From: Laura Gibbons <Laura.Gibbons@arun.gov.uk>
Sent: 22 March 2022 16:00
To: Planning.Responses <Planning.Responses@arun.gov.uk>
Cc: Simon Davis <Simon.Davis@arun.gov.uk>
Subject: RE: Planning Consultation on: AL/29/22/DOC

Engineers Comments Regarding Condition 11

Application No: AL/29/22/DOC
Registered: 3rd March 2022
Site Address: Land At Wings Nursery Lidsey Road Woodgate PO20 3SU
Description of Works: Approval of details reserved by condition imposed under AL/20/21/PL relating to condition 11-discharge of flows.

Drawing Title Existing Watercourse Alterations General Arrangement and Levels

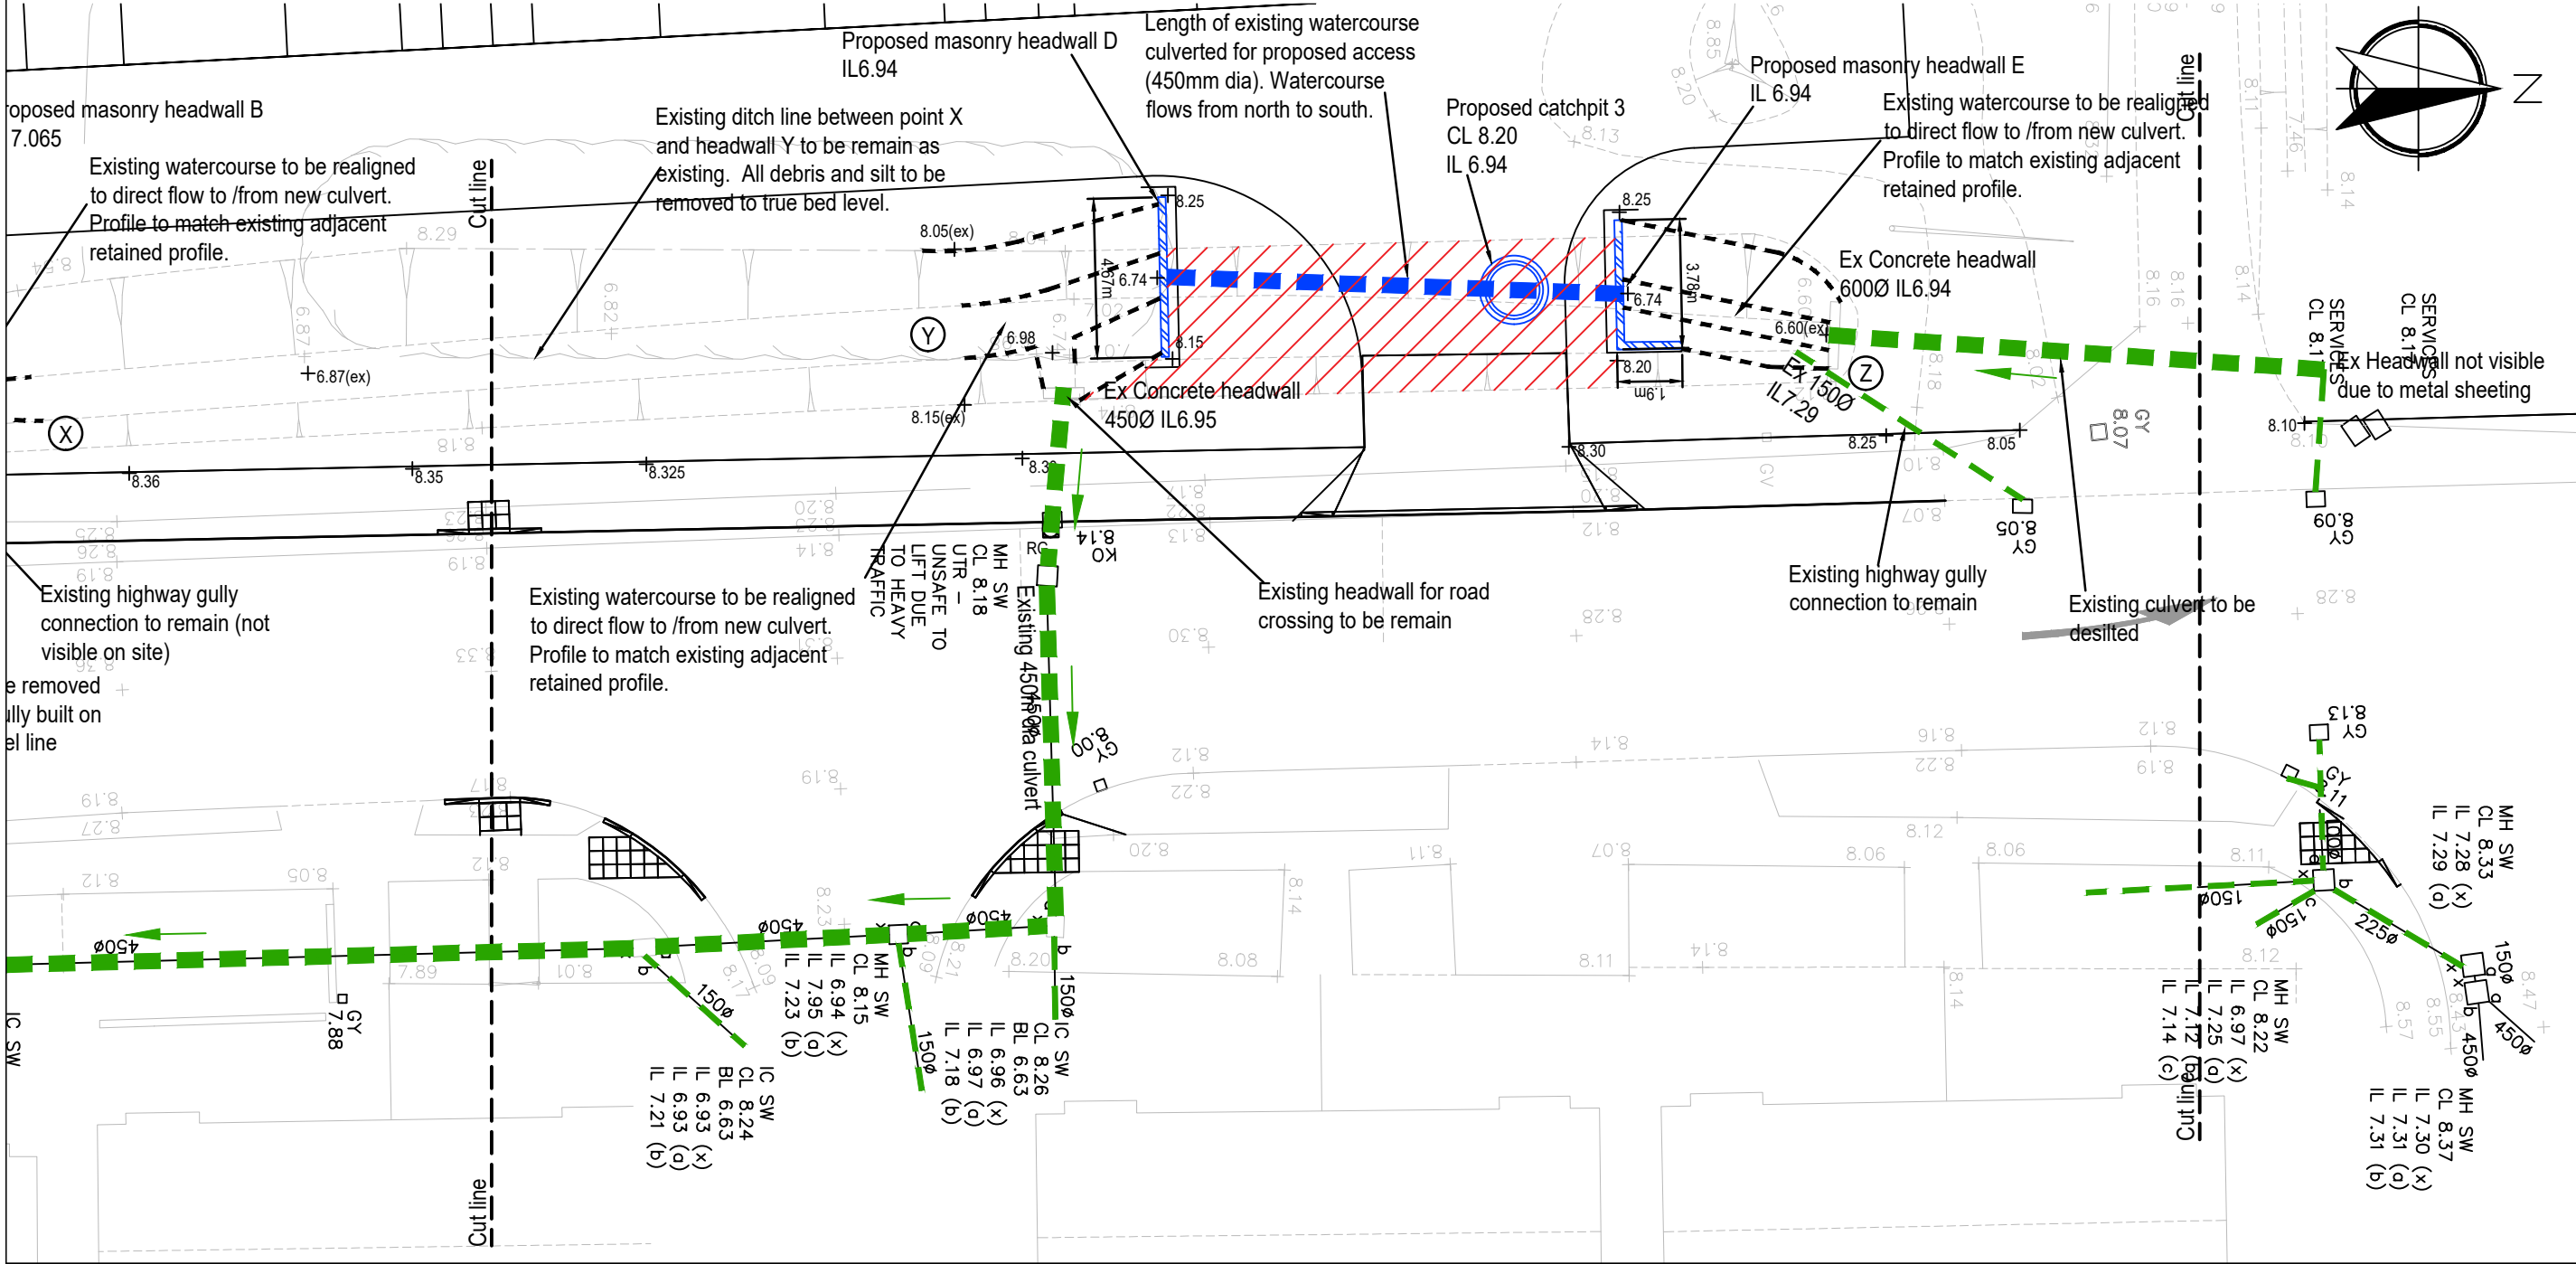
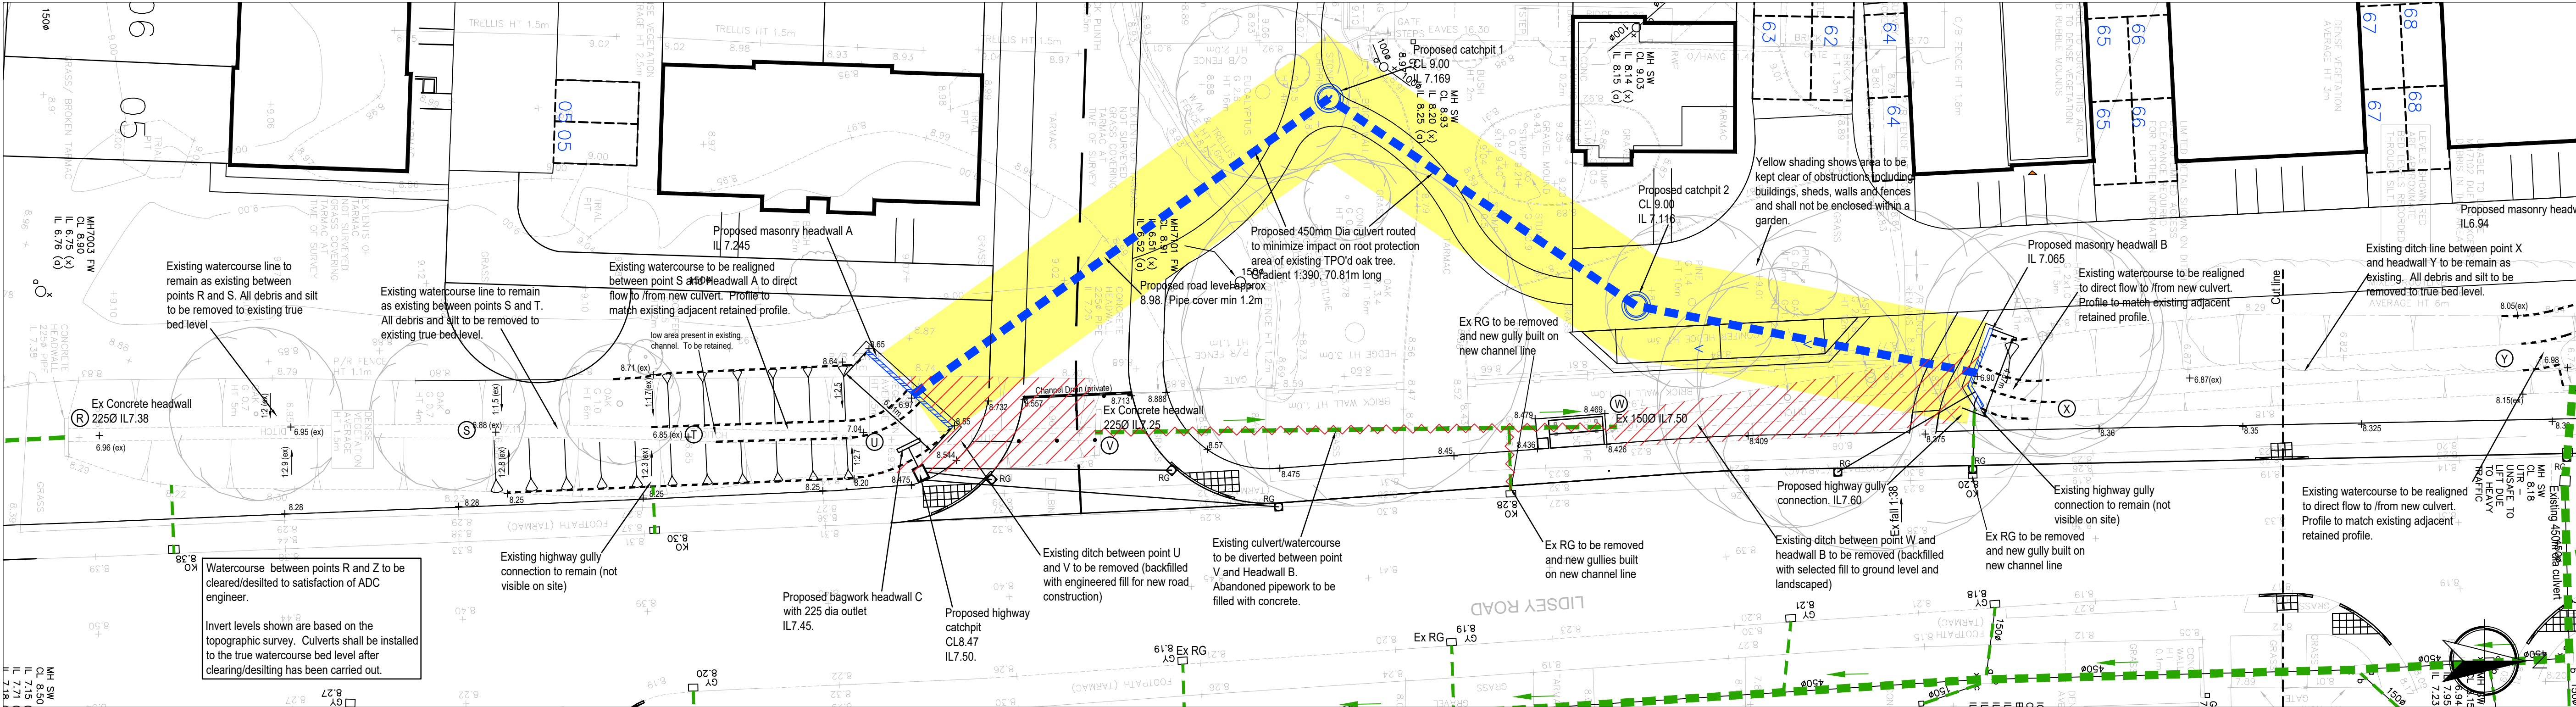
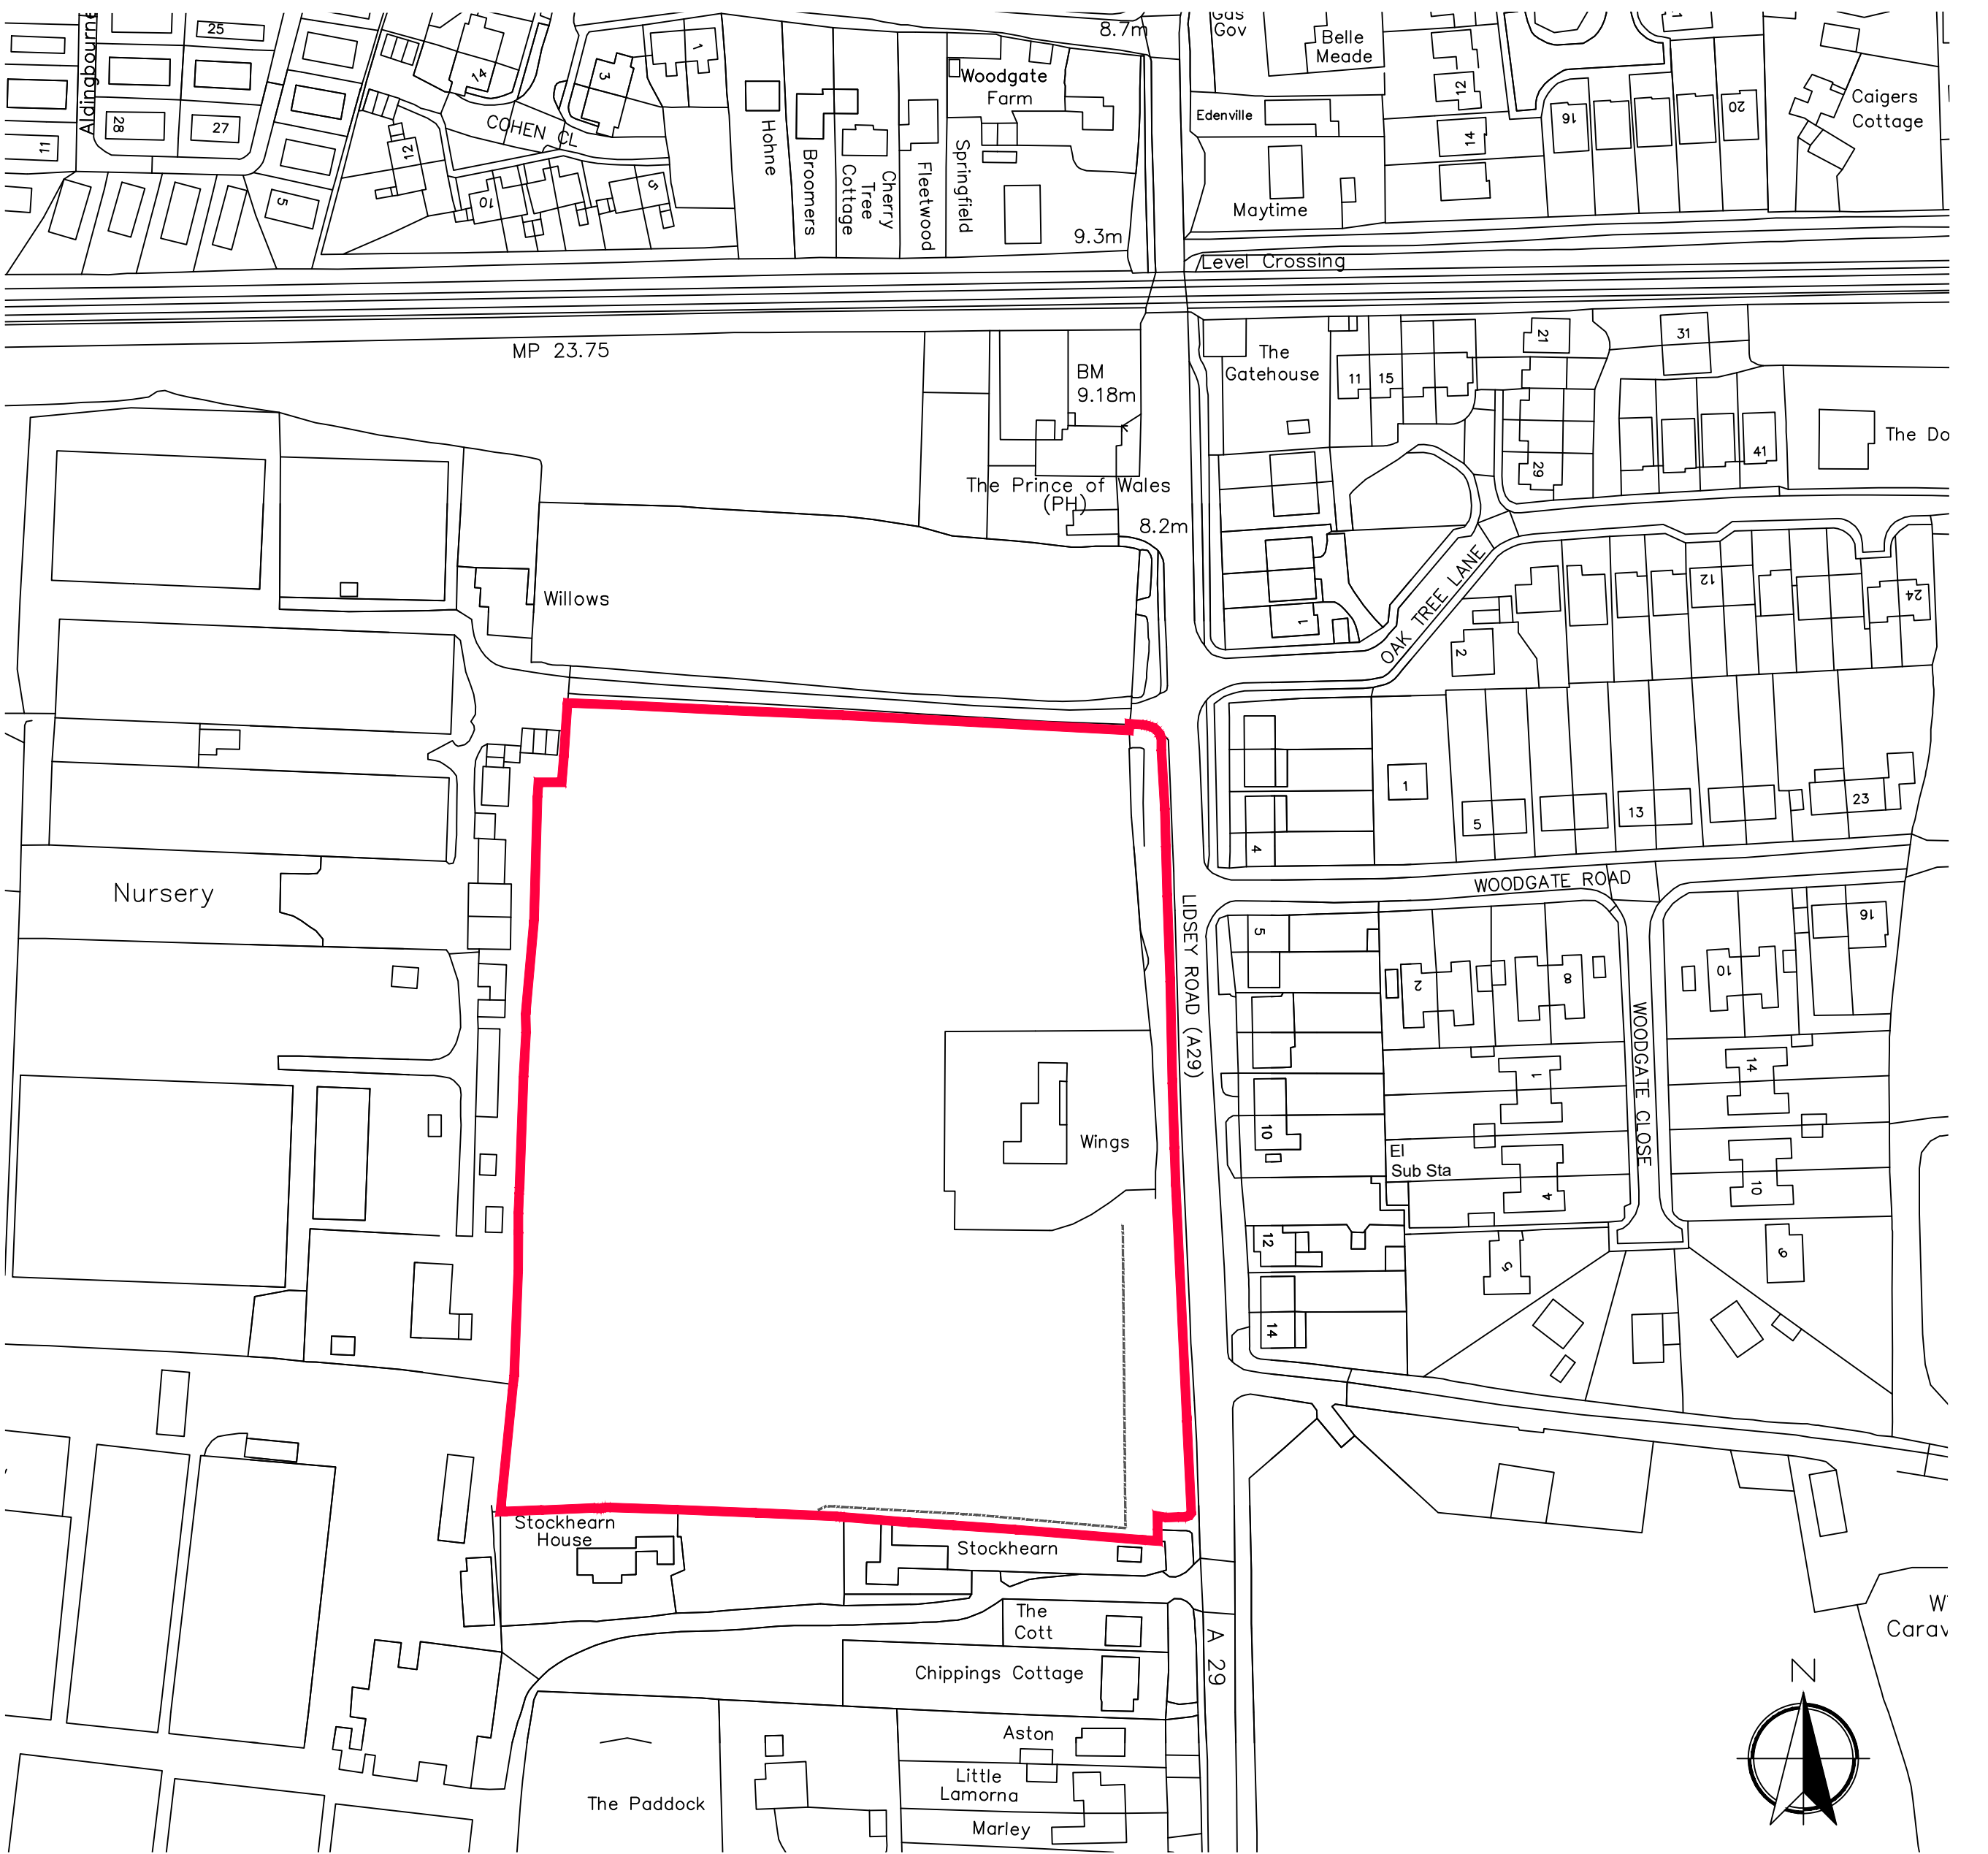
Please provide evidence of land drainage consent for the proposed outfall connections from the development, i.e. both that to the proposed culvert, and the further headwall to the open watercourse further north.
